**SSD 6387 MOD 4 – 1 Burroway Road – Wentworth Point**

**Section 96(1A) amendment to approved mixed use development**

**City of Parramatta Submission**

Project Title
JEWEL RETAIL
1 BURROWAY RD, WENTWORTH POINT, THE WHARF SITE.
SYDNEY OLIMPIC PARK
Drawing Title
CAFE DESIGN

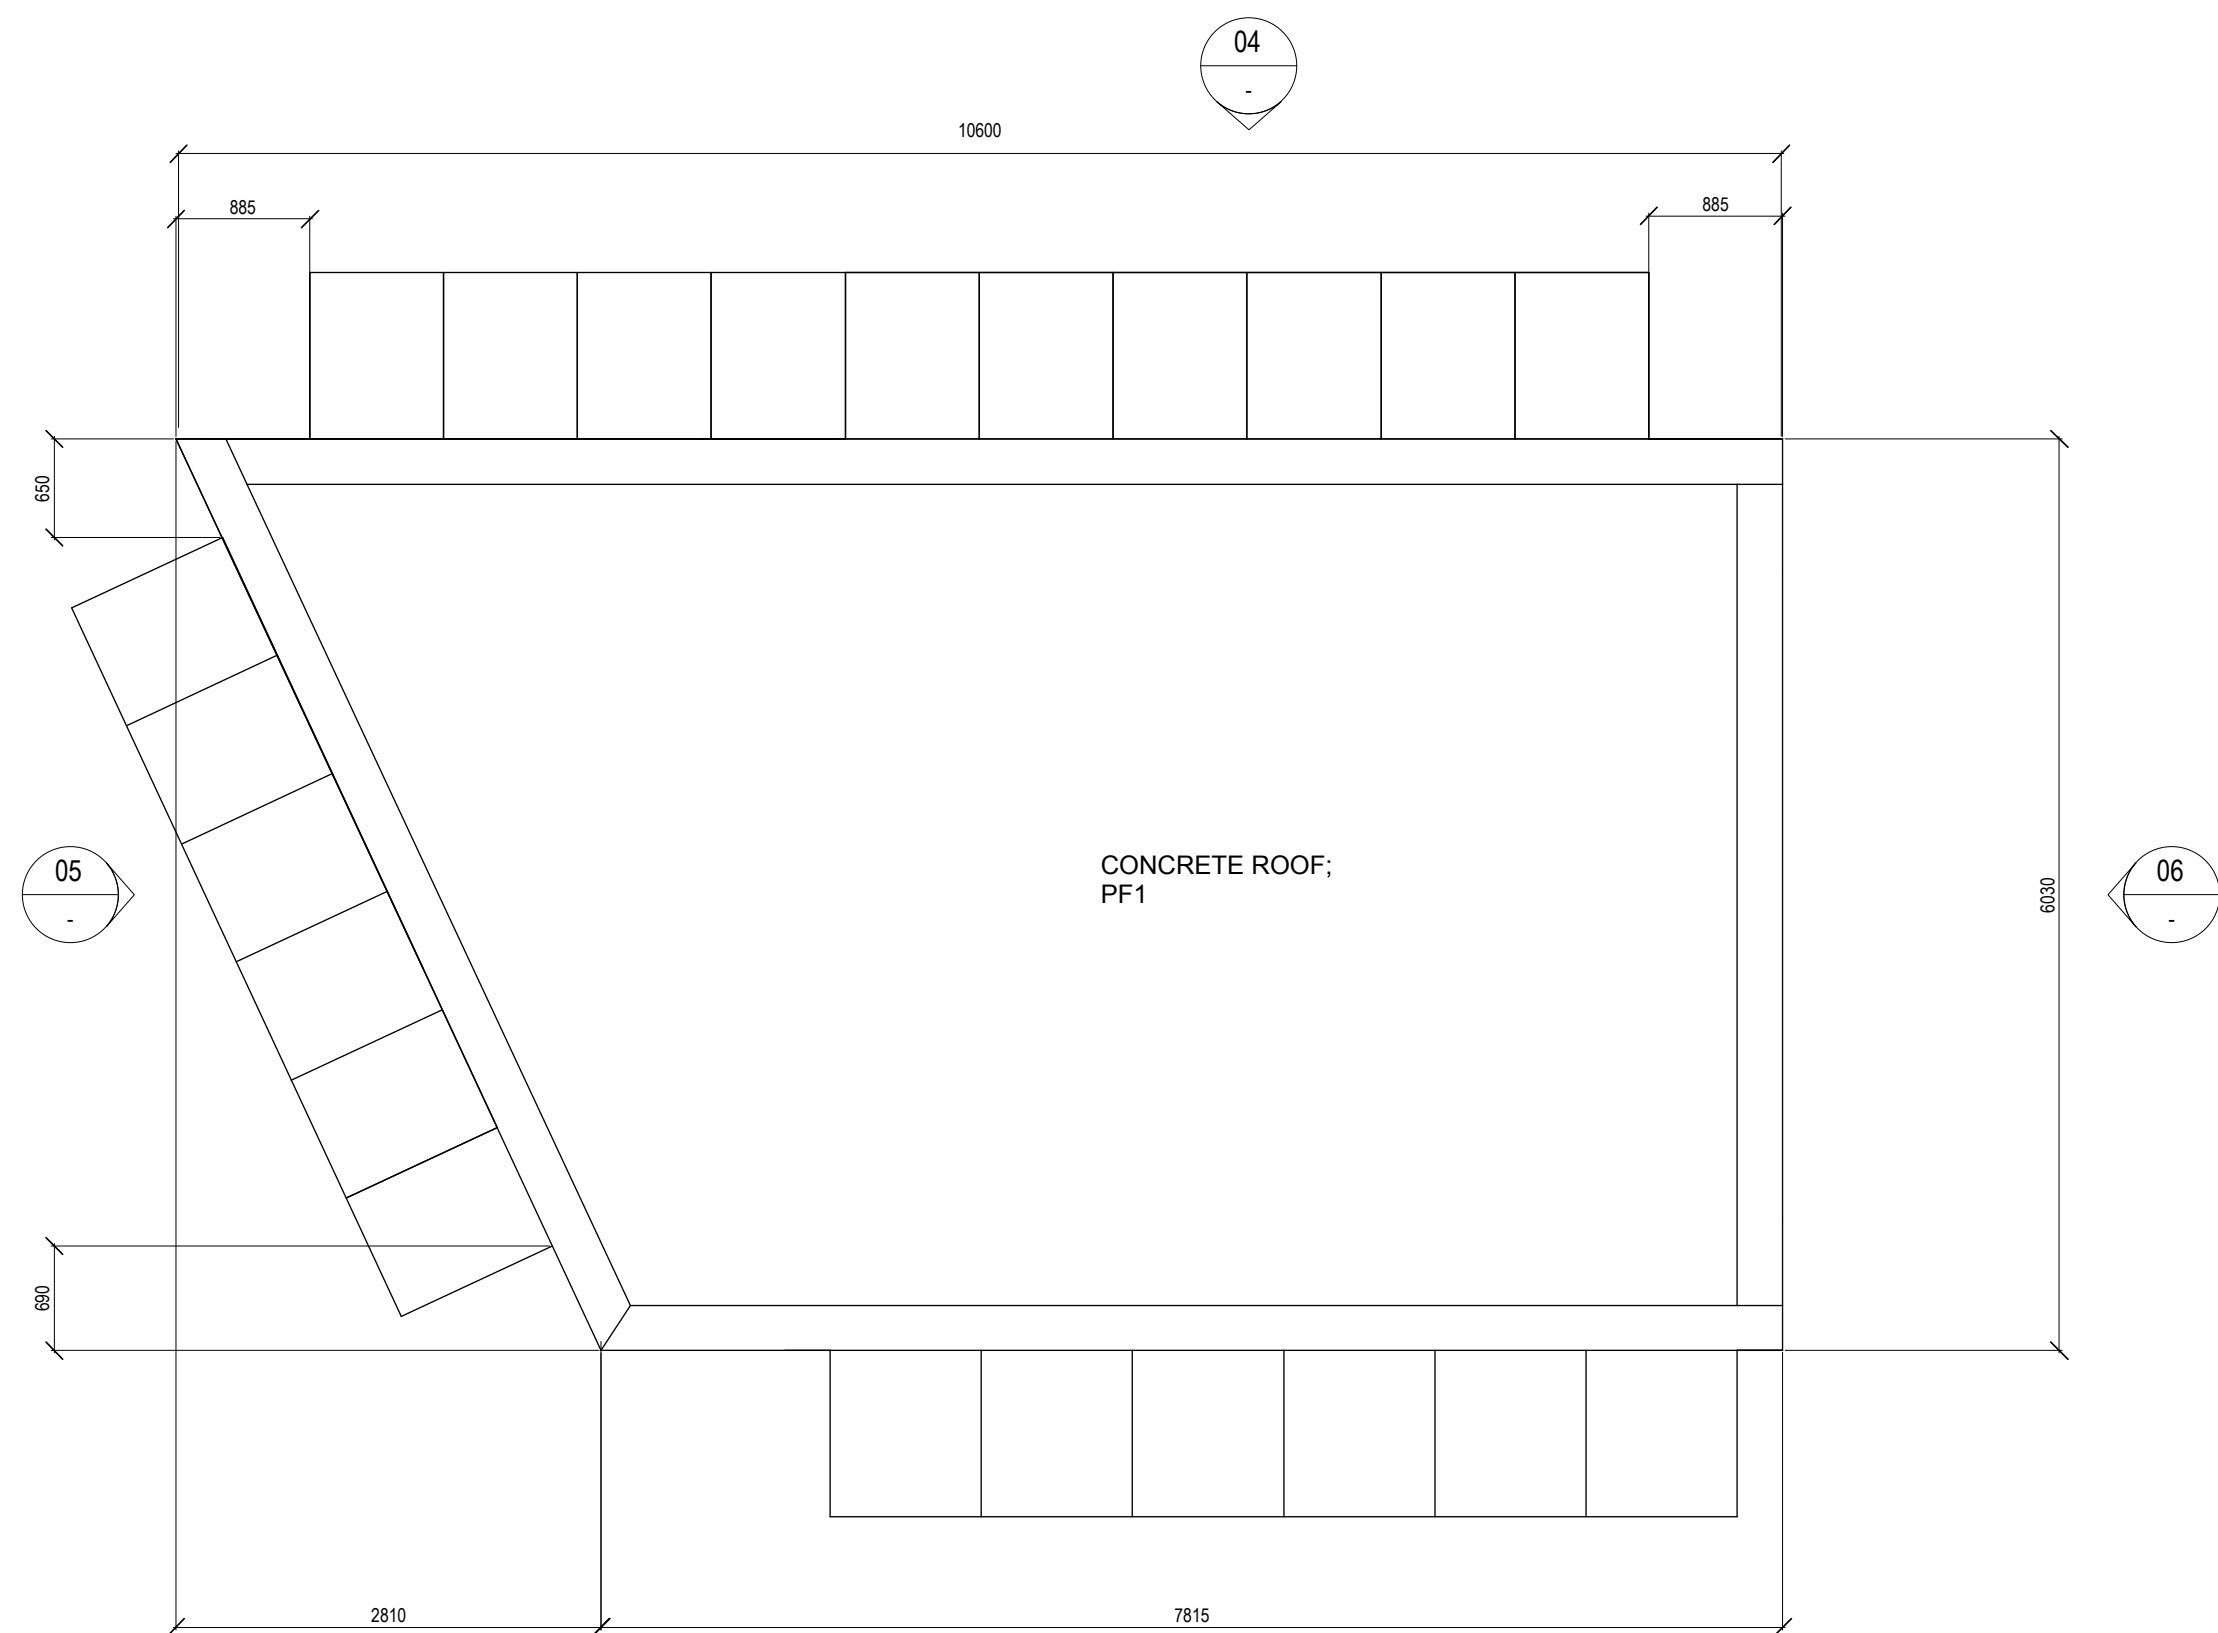
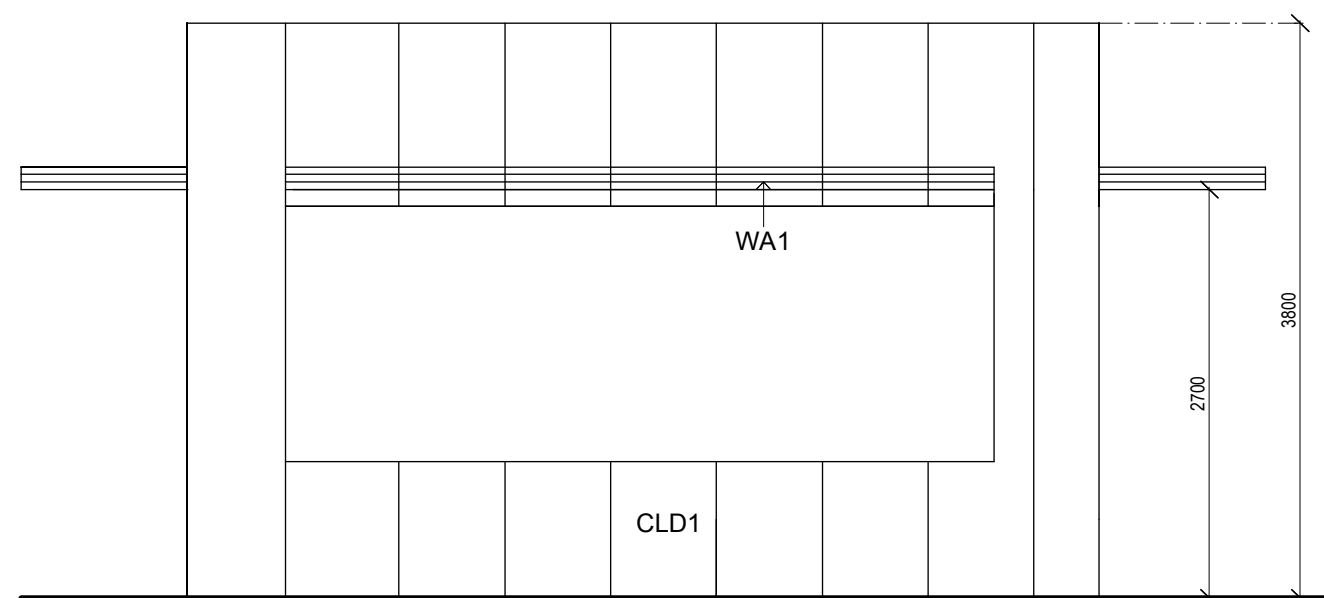
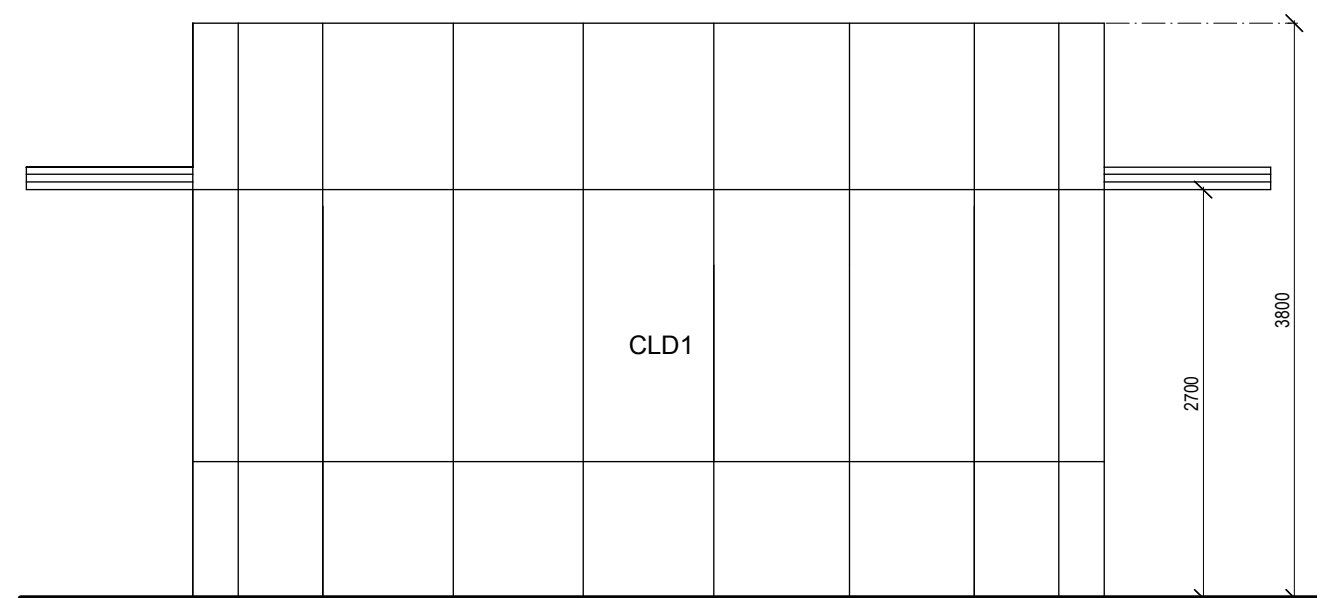
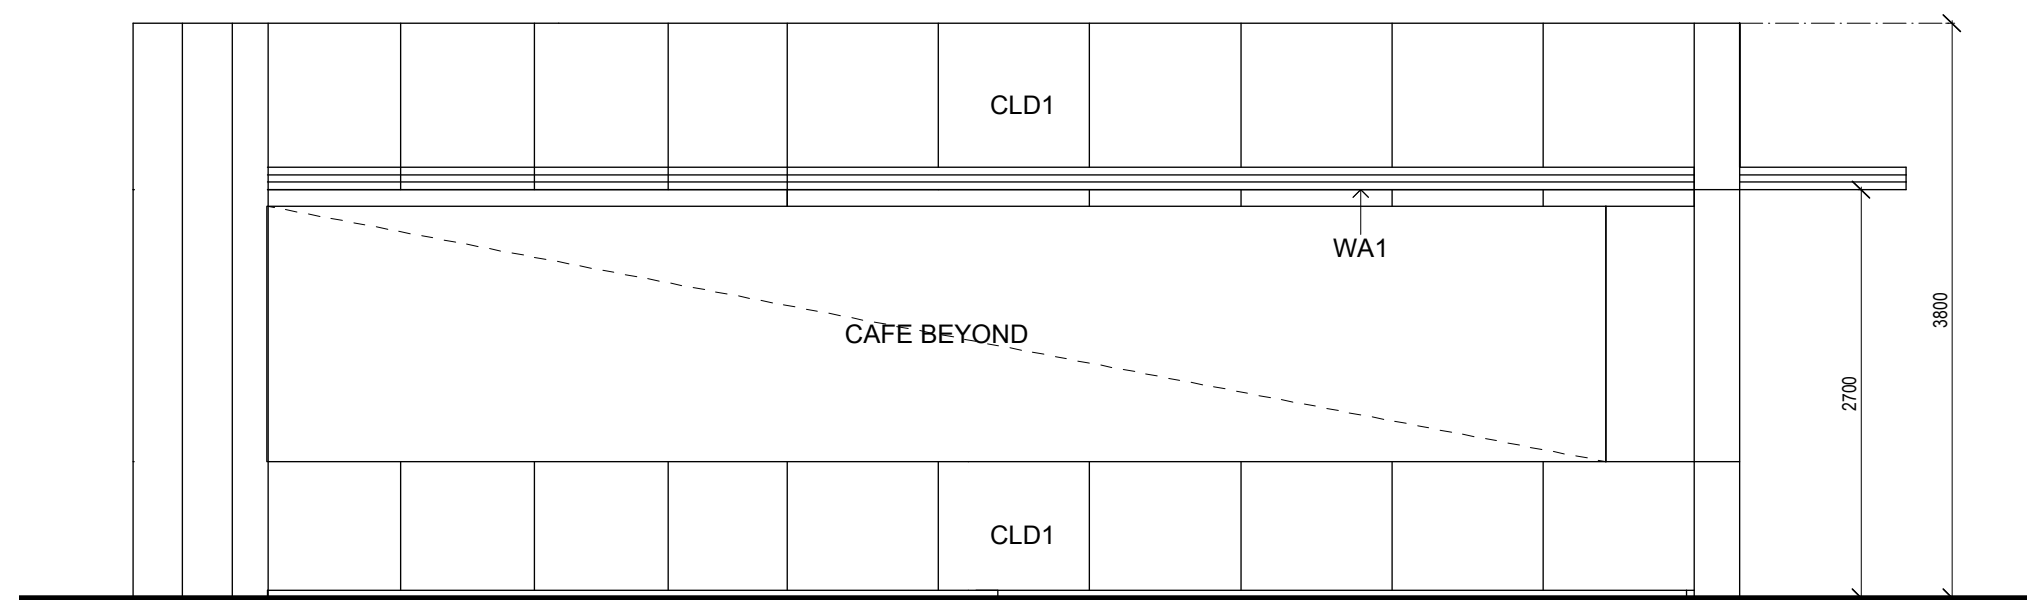
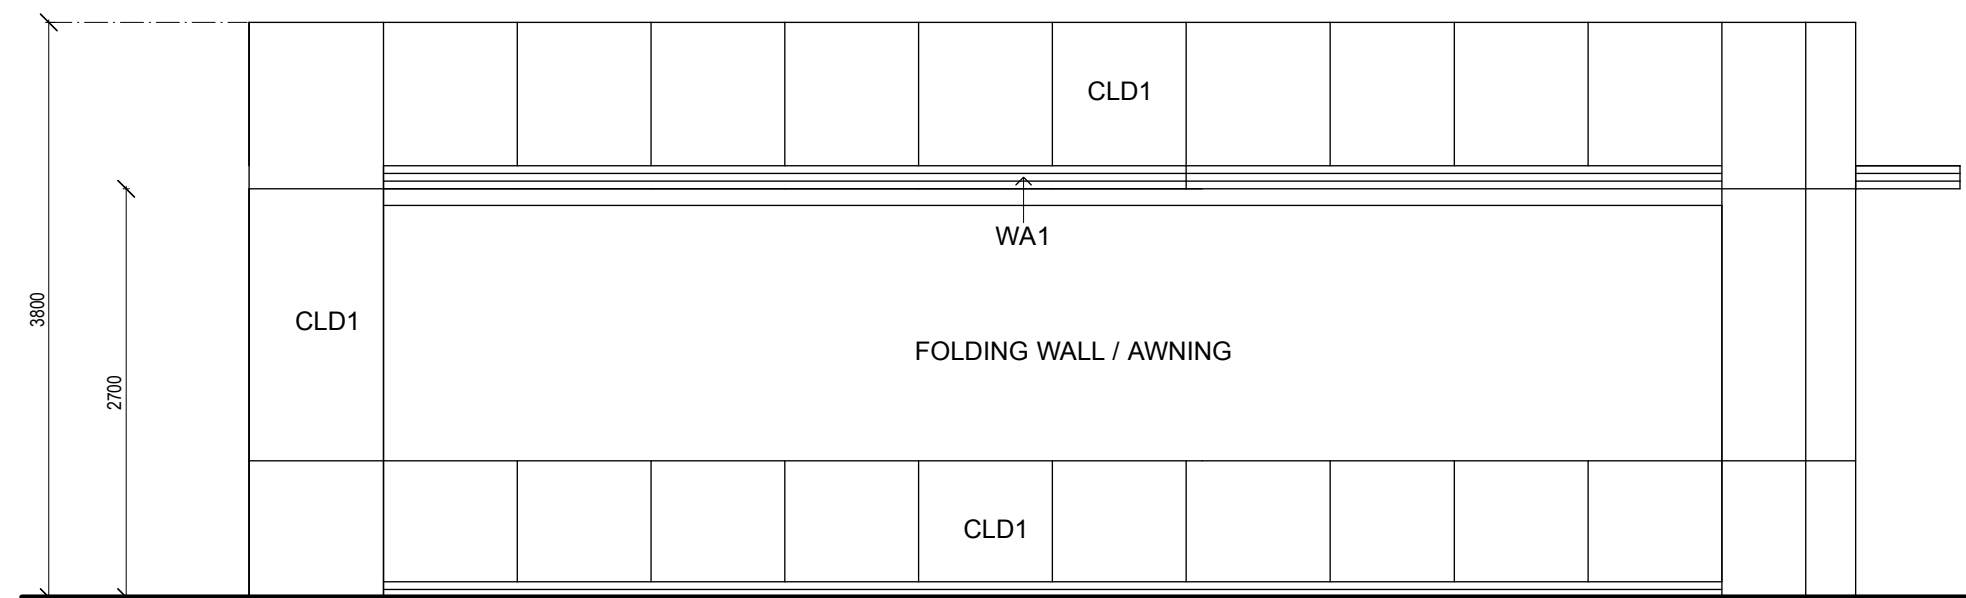
Although we feel it is preferable that this pedestrian plaza area be maintained solely as a wide open thoroughfare to enhance the public domain, we acknowledge the significant improvements to the location and size of the café structure. The modifications made assist in minimising the impacts previously raised in our original submission. In this regard, Council raises no further objection to the proposal. It is considered that the structure should be of high quality materials and finishes to complement the plaza environment.

Project Title  
**JEWEL RETAIL**  
1 BURROWAY RD. WENTWORTH POINT, THE WHARF SITE.  
SYDNEY OLYMPIC PARK  
Drawing Title  
**ROOF PLAN & SECTION**

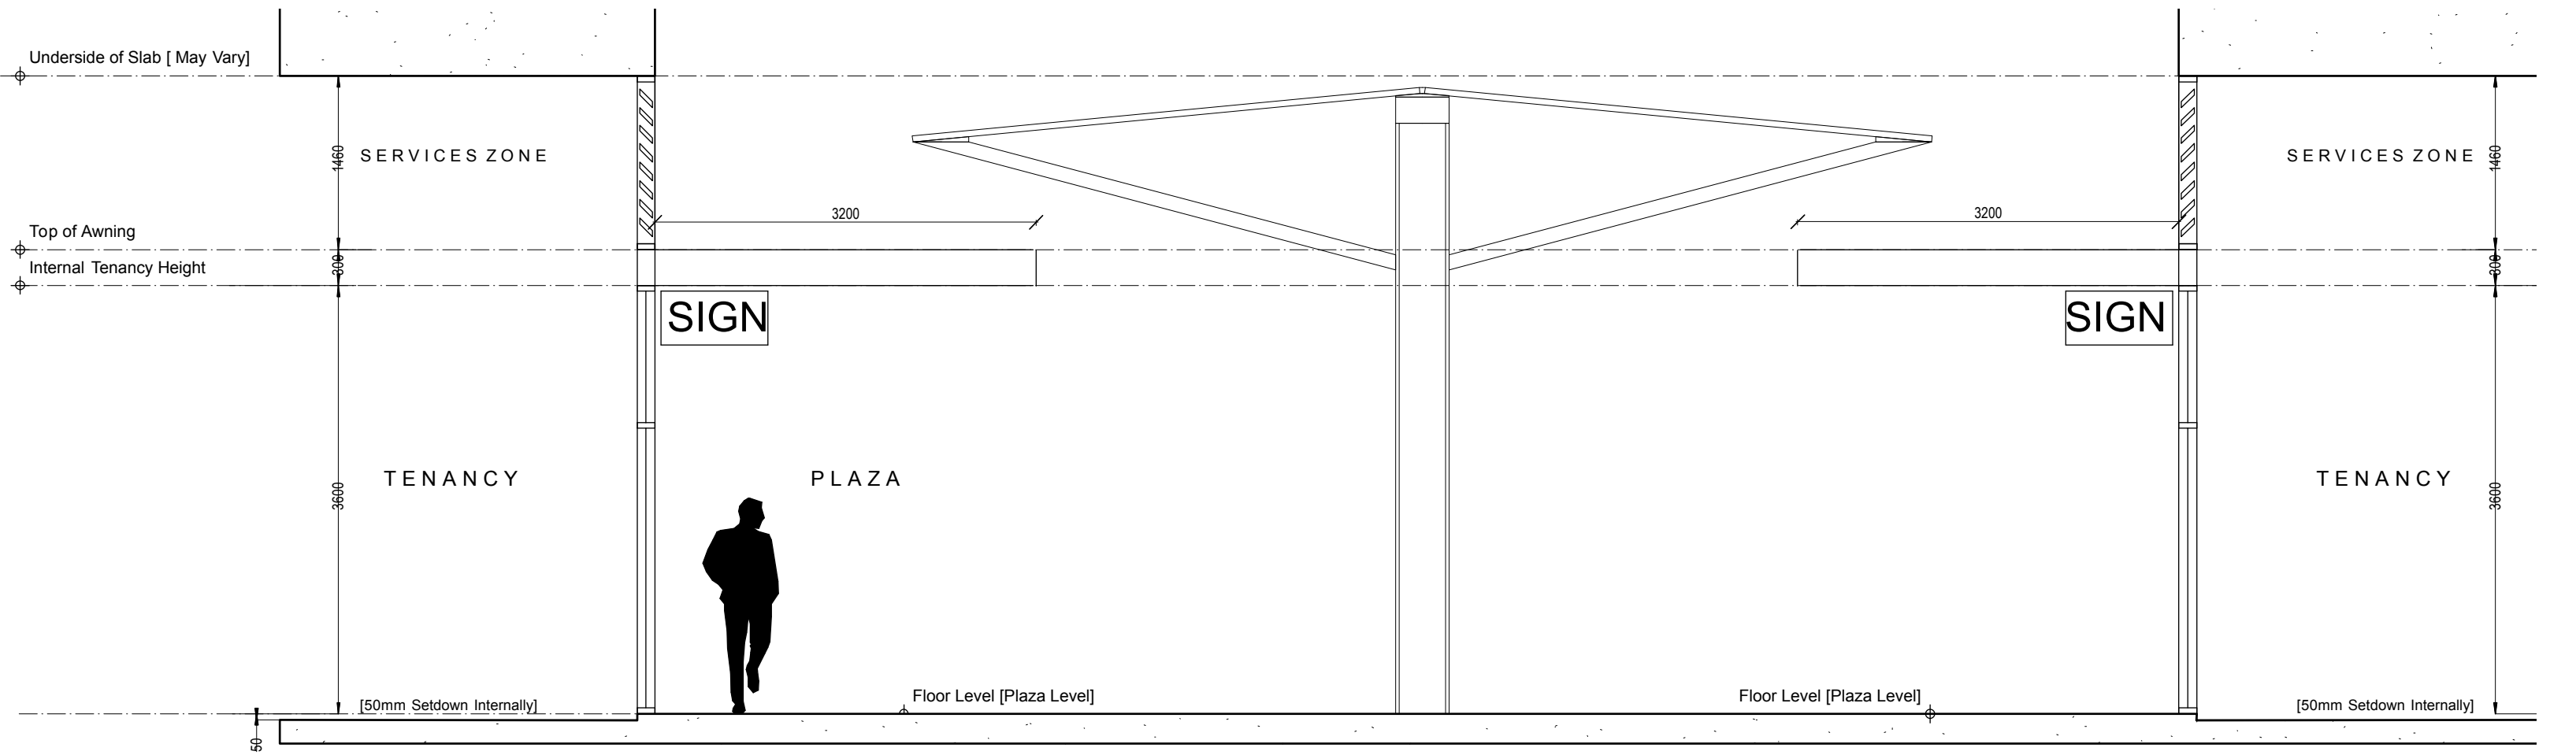
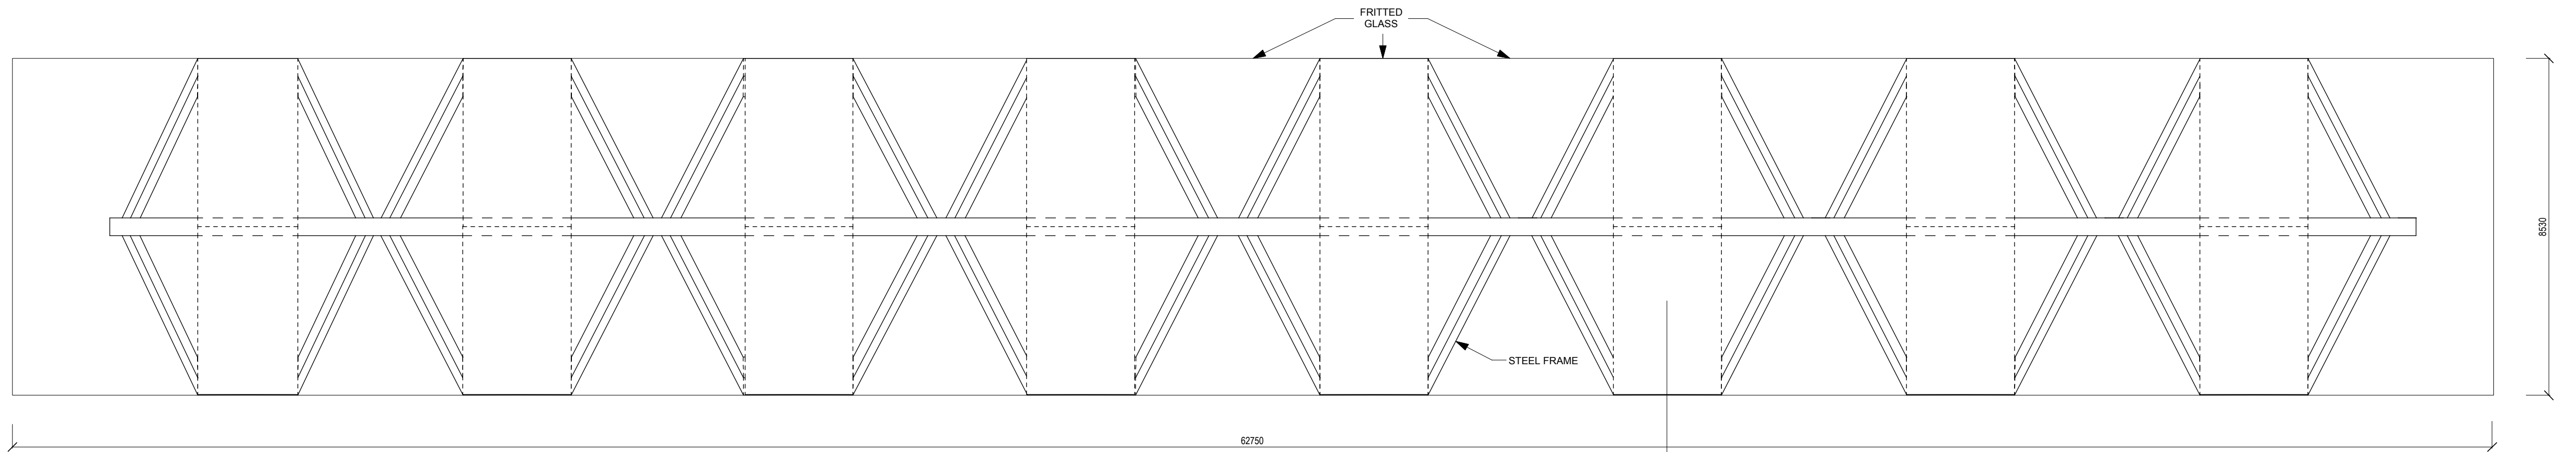
Comments noted. No issues raised. We trust the Department will ensure that the design and construction of the plaza area will be carried out in accordance with the Building Code of Australia, the Disability (Access to Premises – Buildings) Standards 2010 and Australian Standard 1428.2-1992.
